CITY OF ALBUQUERQUE

**RE: 4331 Wyoming Blvd NE
Grading and Drainage Plan
Engineer's Stamp Date: 2/26/25
Hydrology File: G19D004
Case # HYDR-2025-00064**

Based upon the information provided in your submittal received 02/26/2025, the Grading & Drainage Plan is not approved for Building Permit and Grading Permit. The following comments need to be addressed for the approval of the above referenced project.

RONALD R. BOHANNAN P.E. #7868	THE WYMONT ALBUQUERQUE, NM	DRAWN BY pm
	GRADING AND DRAINAGE PLAN	DATE 11-2-21
	TIERRA WEST, LLC 5571 MIDWAY PARK PL NE ALBUQUERQUE, NEW MEXICO 87109 (505) 858-3100 www.tierrawestllc.com	DRAWING 2021008-GR
		SHEET # GR-1
		JOB # 2021008

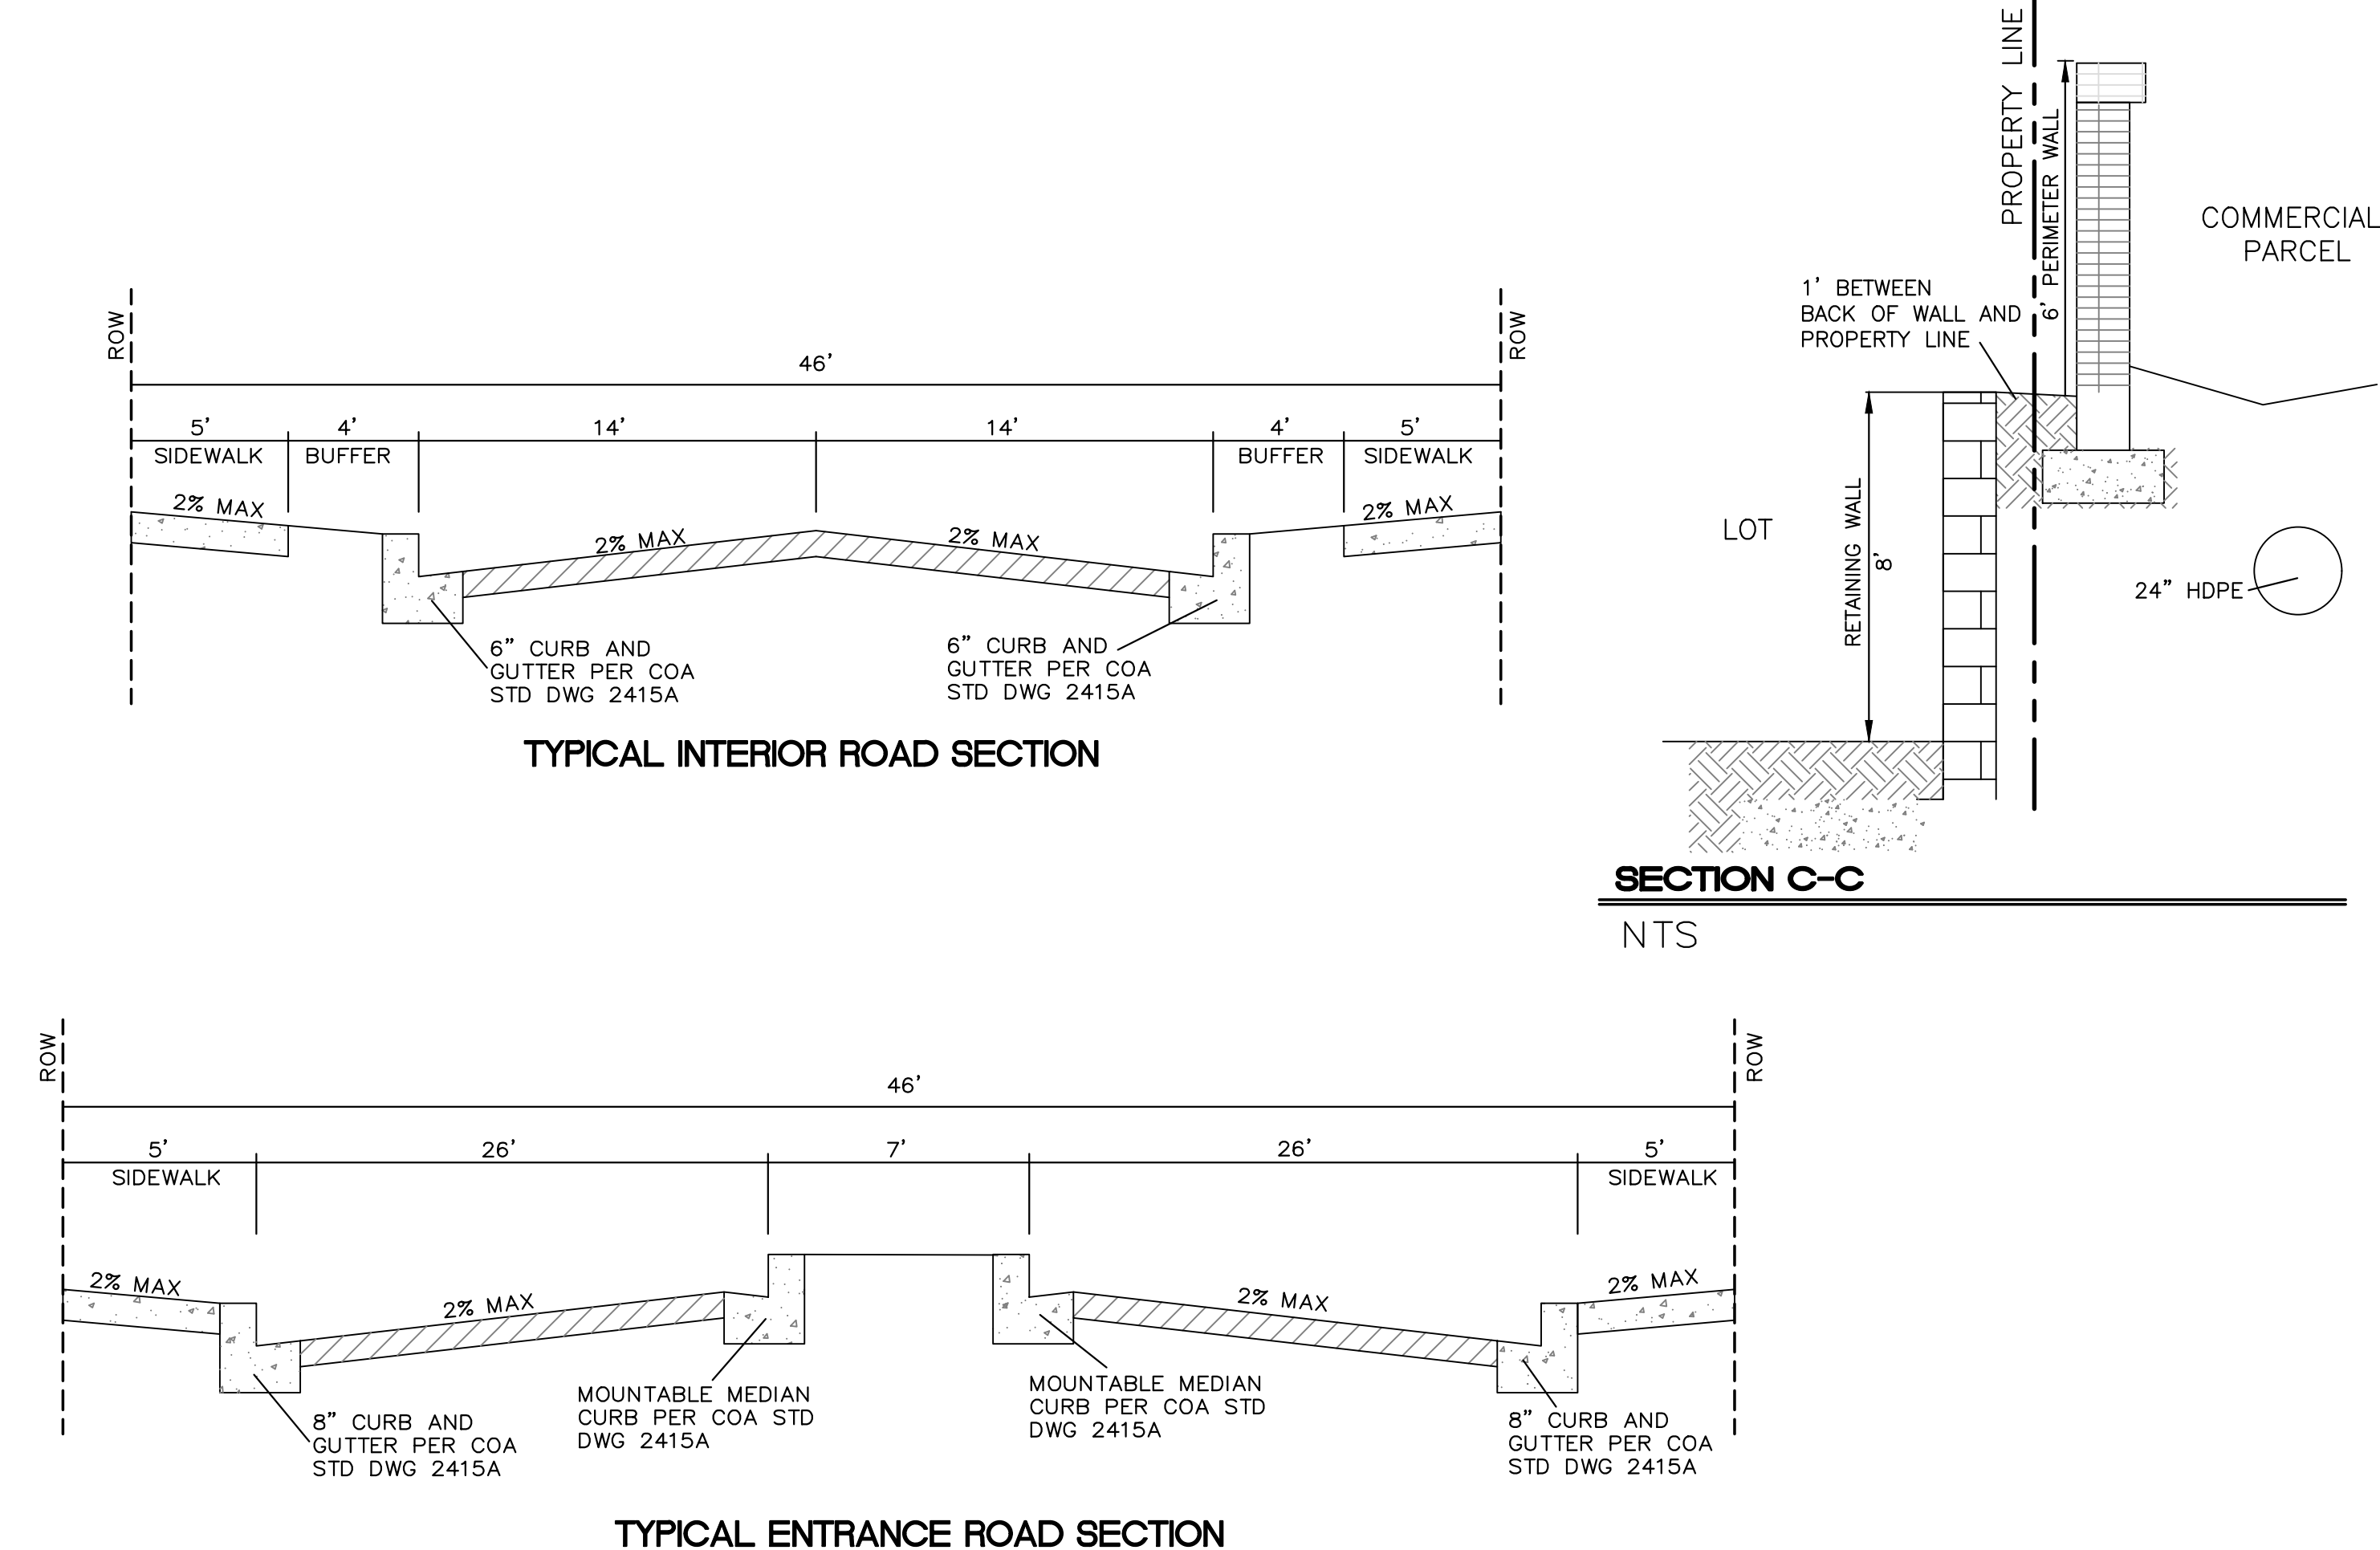
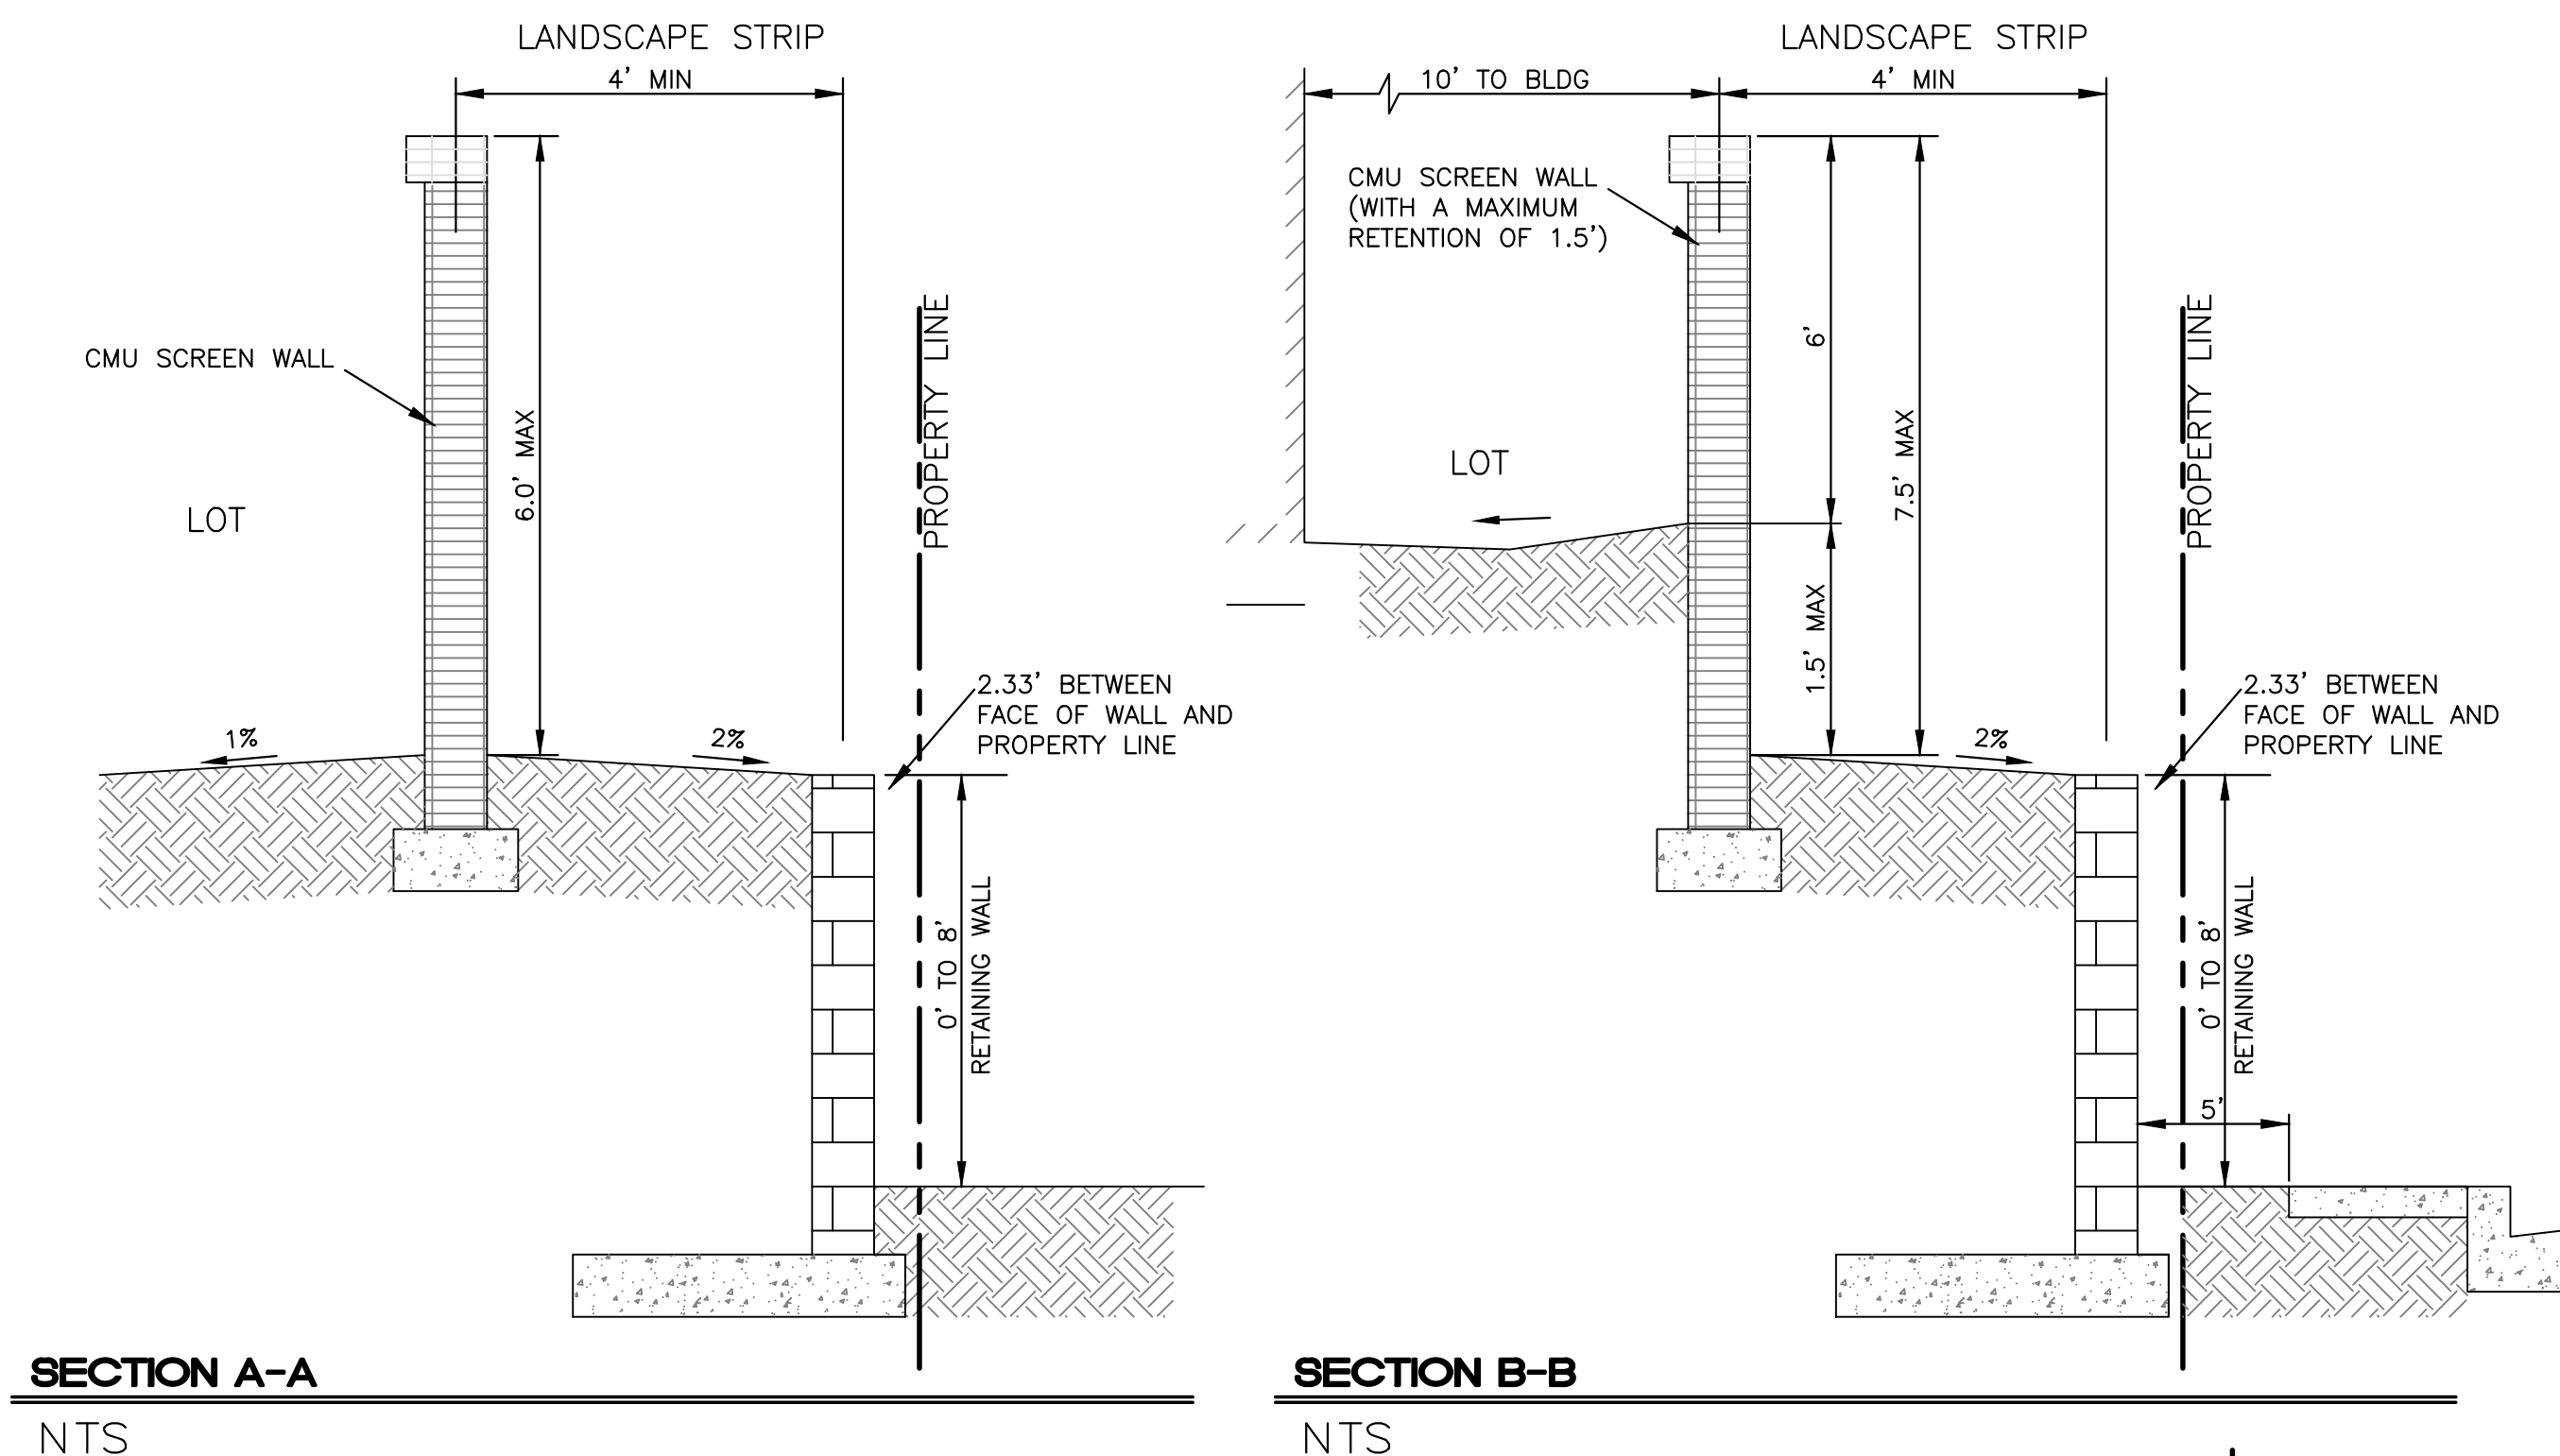
1. Please show the calculations for the SWQV. To calculate the required SWQV, multiply the impervious area draining to the BMP by 0.42 inches for new development sites and 0.26 inches for redevelopment sites. The calculations of both the required and the provided volume of each BMP must be shown on the Grading and Drainage Plan.
